From: Maria Tomalova
Sent: Friday, February 18, 2022 3:58 PM
To: Peter Cleveland [REDACTED]
Subject: FW: Stakers Farm

As far as I am aware, you deal now with the applications for Stakers Farm.

I discussed your proposal with Martyn and we both are of an opinion that the conditions only would not solve the problems and some amendments should be done.

BARNS 1&2 PROPOSED NORTH WEST ELEVATION

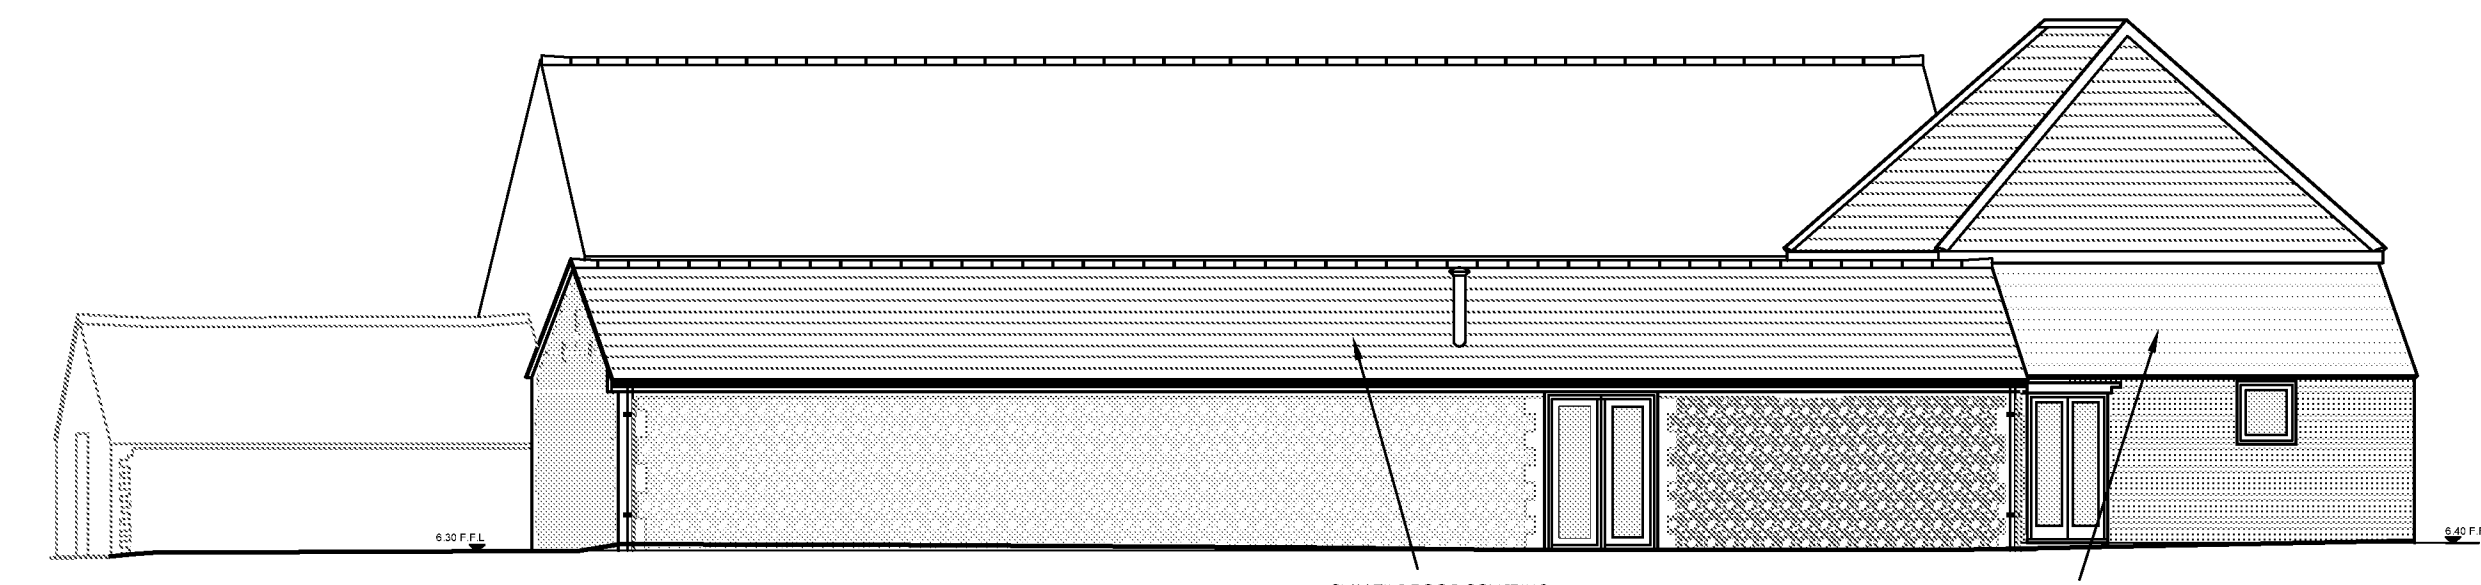
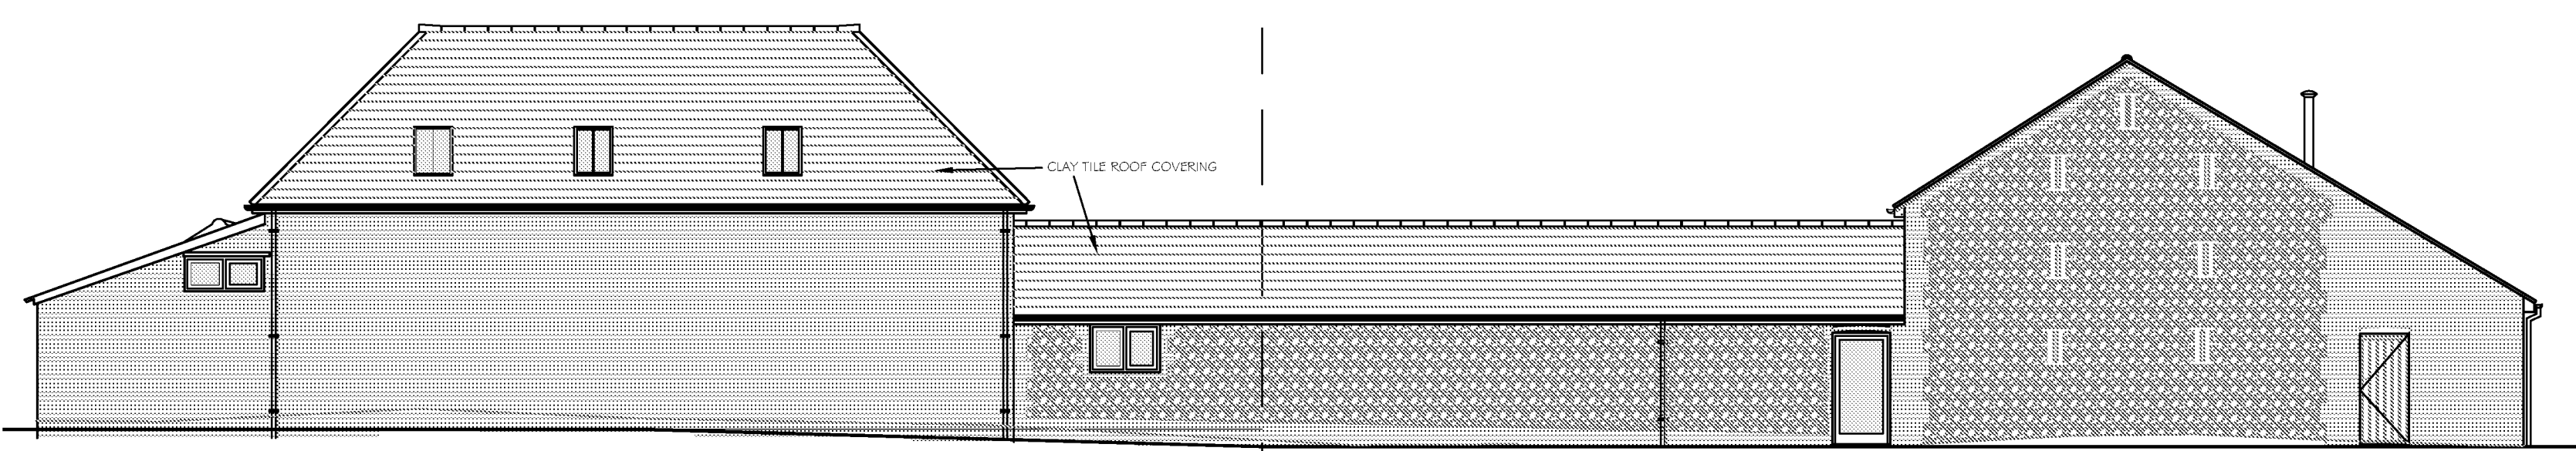
All the horizontal divisions should be back in the position where they were in approved plans and the same position should be maintain within all fenestration facing to the yard. The same apply for the largest opening. The replacement of the existing door (not original) as proposed is not acceptable and it would be helpful to discuss the replacement. There some other thing that should be clarified.
